June 16, 2015

**Re: Gordon Warehouse
8508 Constitution NE
Traffic Circulation Layout
Engineer's/Architect's Stamp dated 6-12-15 (J20-D037A)**

May 22, 2015

**Re: Gordon Warehouse
8508 Constitution NE
Traffic Circulation Layout
Engineer's/Architect's Stamp dated 5-8-15 (J20-D037A)**

Grading & Drainage
Plan W/ TCL Elements

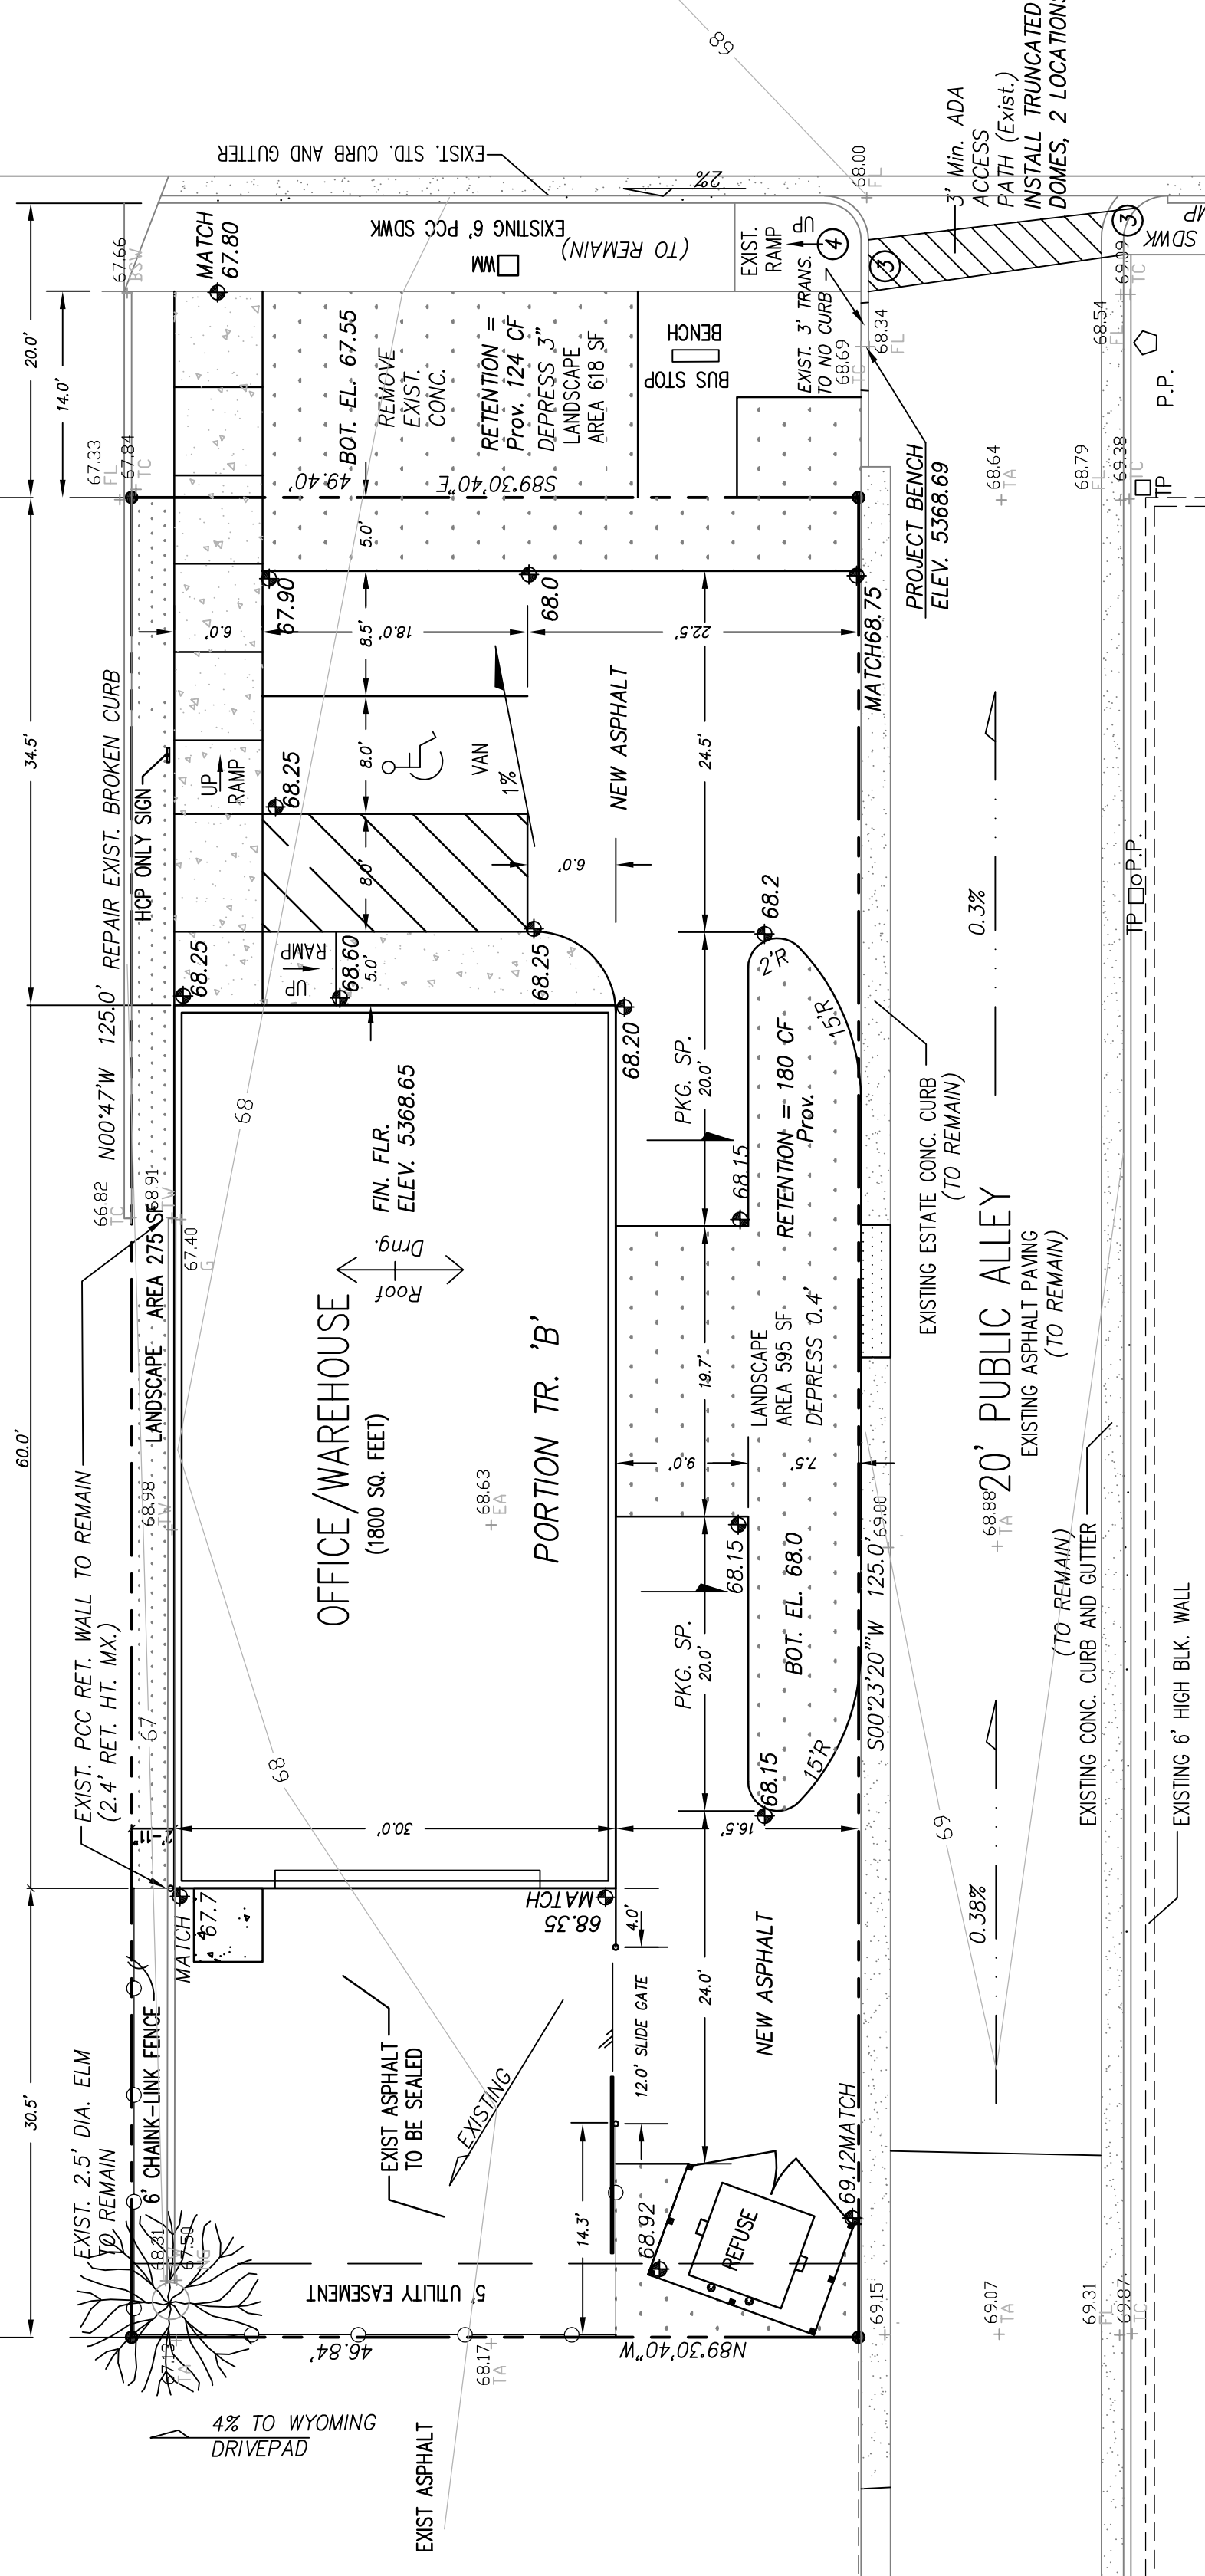
1. A scale of 1"=20' is recommended for sites less than 5 acres.
2. Please provide a separate TCL Site Plan, separate from Drainage Plan.
3. Please provide a Legend notation for Landscaping. It is hard to differentiate the landscaping notation from the cement notation.

4. Please identify all buildings, doors, structures, sidewalks, curbs, drive pads, walls and anything that influences the parking and circulation on the site.

5. Identify all existing access easements and rights of way with dimensions.
6. Identify the right of way width, medians, curb cuts, and street widths on both Constitution Ave. and the Public Alley.

7. Please review the regular and ADA parking on the northeast corner of the proposed building. There does not seem to be enough of a turning radius for the ADA parking customers backing out of the ADA parking without backing up into the Public Alley. Please consider moving the regular parking space at the northeast corner further south or to another location. Please provide a Turning Template Analysis and Exhibit on the resubmittal.

8. Please call out slope (12:1 Max) of ADA pedestrian pathway and provide a detail.
9. Please provide detail of truncated domes on the sidewalk at the intersection of Constitution Ave. and the Pubic Alley. *not needed*

10. The handicap accessible spaces must be a minimum of 8.5 feet in width.

11. The handicap accessible spaces must include an 8-foot wide van access aisle; all other aisles should be 5 feet in width.
12. The ADA van accessible sign must have the required language per 66-7-352.4C NMSA 1978 **"Violators Are Subject to a Fine and/or Towing."**

13. The ADA access aisle shall have the words **"NO PARKING"** in capital letters, each of which shall be at least one foot high and at least two inches wide, placed at the rear of the parking space so as to be close to where an adjacent vehicle's rear tire would be placed. (66-1-4.1.B NMSA 1978)

14. Show all drive aisle widths and radii.
15. List radii for all curves shown; for passenger vehicles, the minimum end island radius is 15 feet. Landscape island radius for delivery trucks, fire trucks, etc. is 25 feet or larger

16. A five-foot keyway is required for dead-end parking aisles. This is applicable to the ADA Handicap parking spaces shown on the proposed plan.
17. Per the DPM, a 6 ft. wide ADA accessible pedestrian pathway is required from the public sidewalk to the building entrances. Please clearly show this pedestrian pathway and ramps and provide details.

18. Per the DPM, a 6 ft. wide ADA accessible pedestrian pathway is required from the HC parking stall access aisles to the building entrances. Please clearly detail HC pathway access aisles.

19. Provide a min 6" or max 8" high concrete barrier curb or other acceptable barrier between landscaping and parking areas and/or drive aisles.
20. Design delivery vehicle route needs to be shown.

21. Service vehicle and/or refuse vehicle maneuvering must be contained on-site; provide a copy of refuse approval (if applicable).
22. Please provide a sight distance exhibit (see the *Development Process Manual, Chapter 23, Section 3, Part D.5 Intersection Sight Distance*).

23. Please add the following note to the clear sight triangle: "Landscaping and signage will not interfere with clear sight requirements. Therefore, signs, walls, trees, and shrubbery between 3 and 8 feet tall (as measured from the gutter pan) will not be acceptable in this area."

24. Please specify the City Standard Drawing Number when applicable. Please call out Standard Numbers for ramps and sidewalks.
25. Please include a copy of your shared access agreement with the adjacent property owner.

28. Unused curb cuts must be replaced with sidewalk and curb & gutter. A build note must be provided referring to the appropriate City Standard.
29. Please include two copies of the traffic circulation layout at the next submittal.

Layout Plan

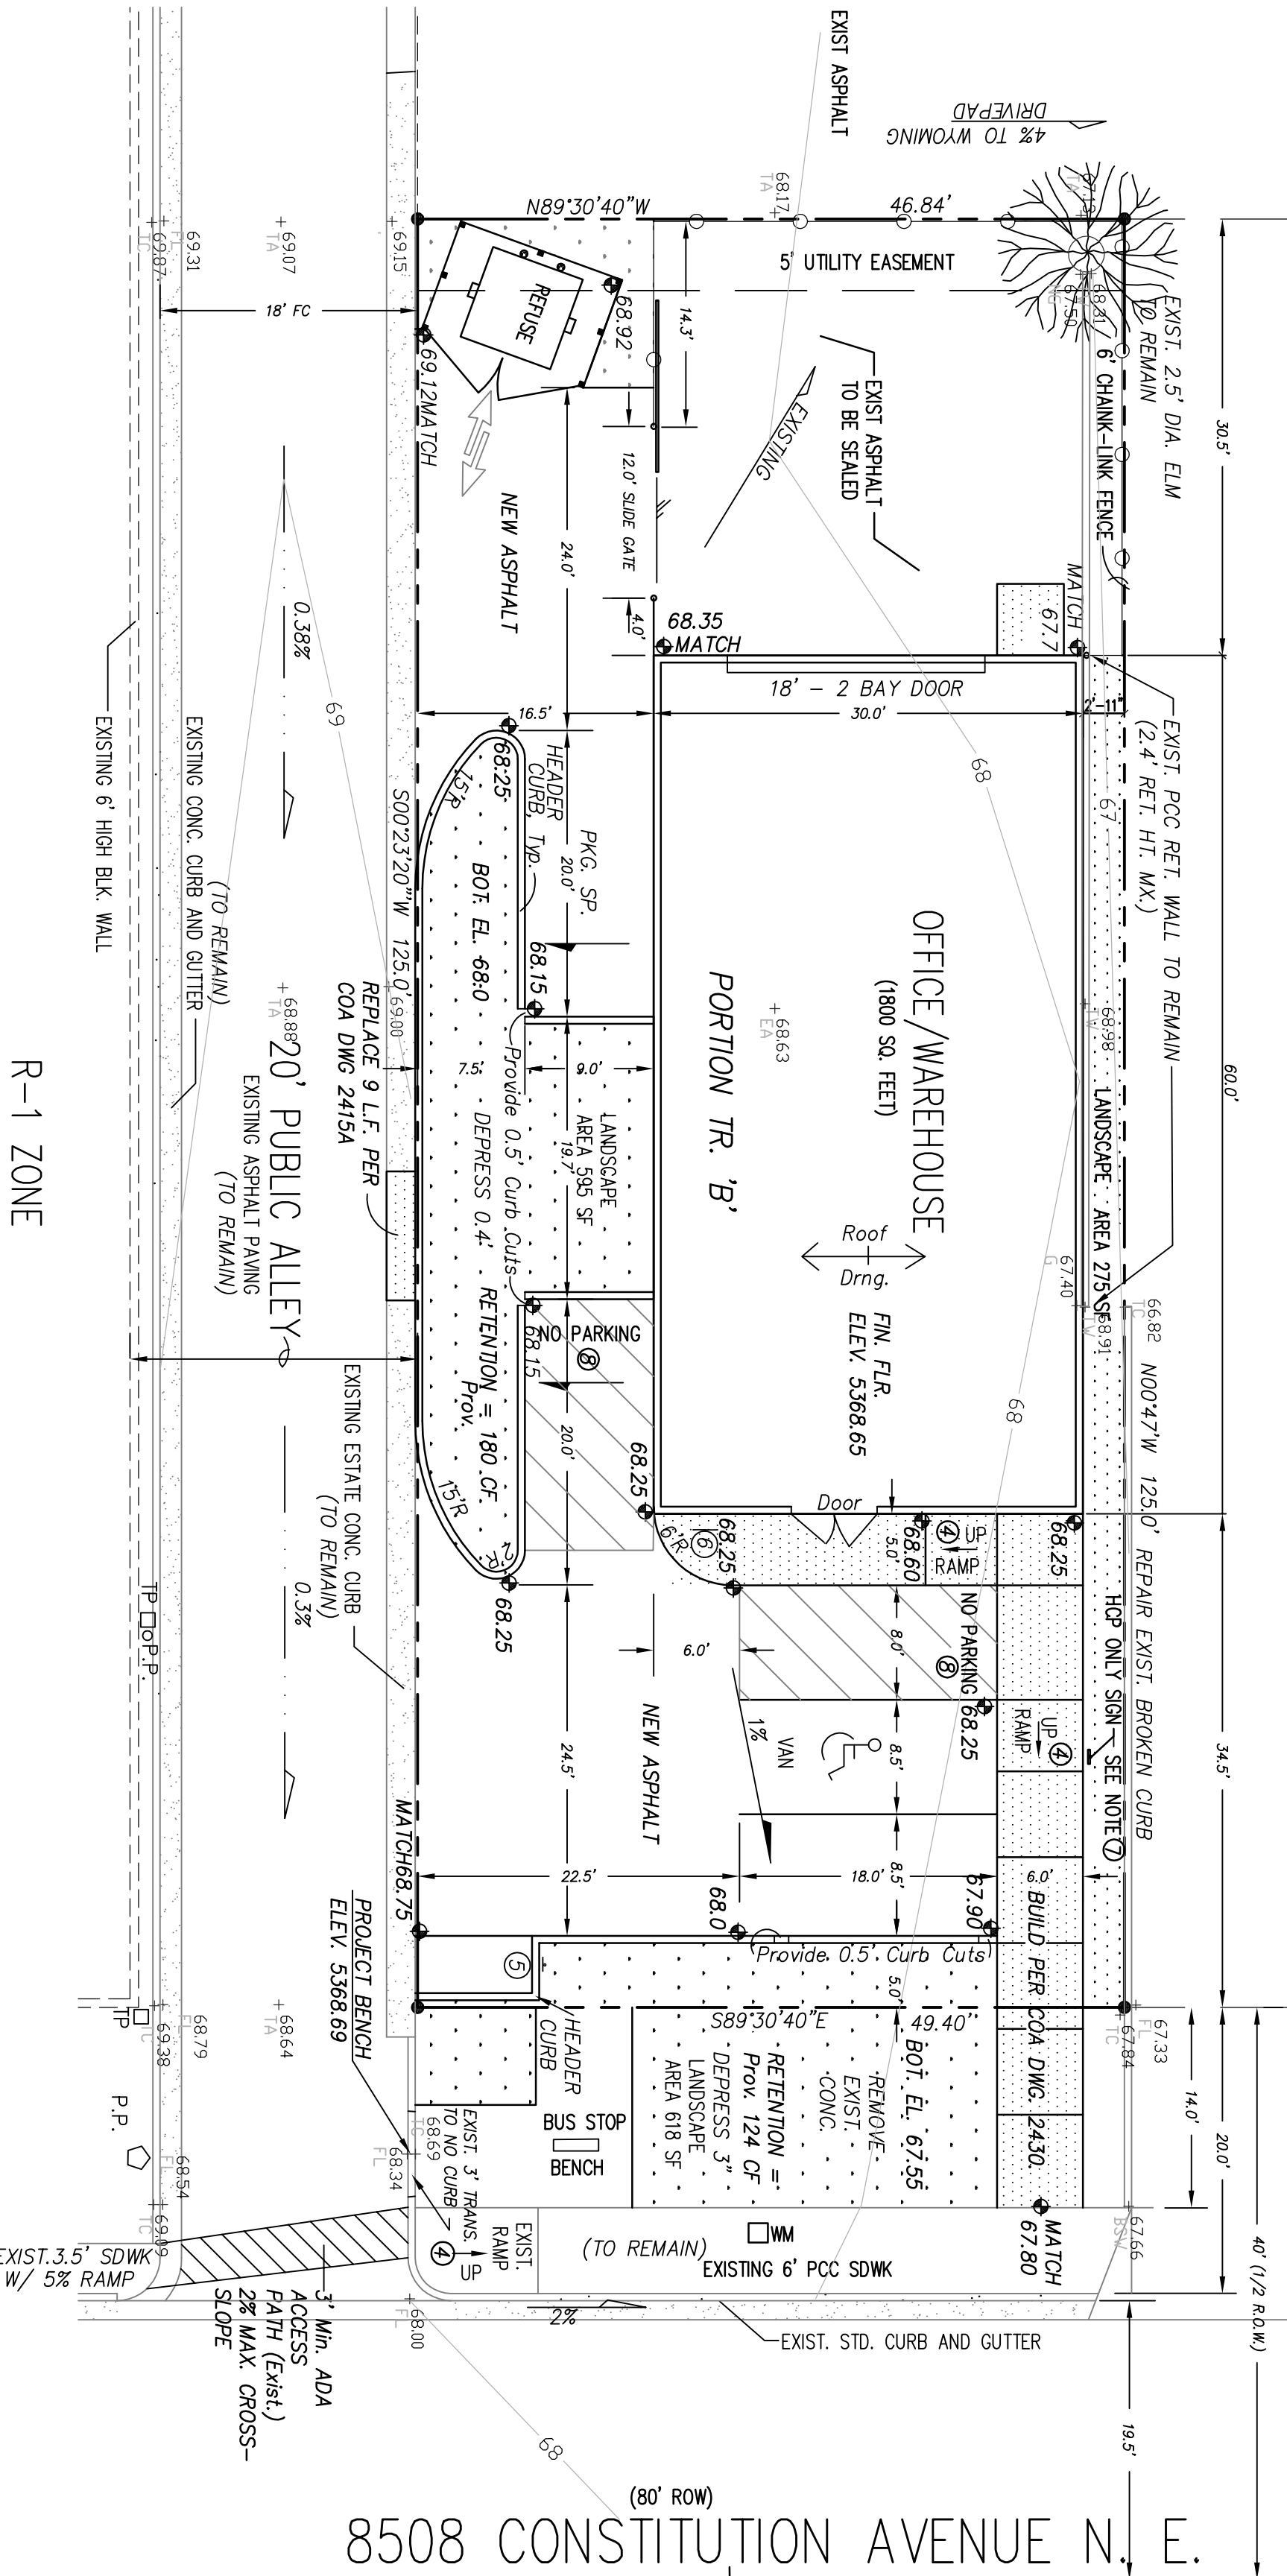
Please note that the ADA access isle painted wording "NO PARKING" must be placed at the rear of the parking space, so as to be close to where an adjacent vehicle's rear tire would be placed. This wording is shown at the top of the parking space on the submittal drawing and must be correct for Final CO.
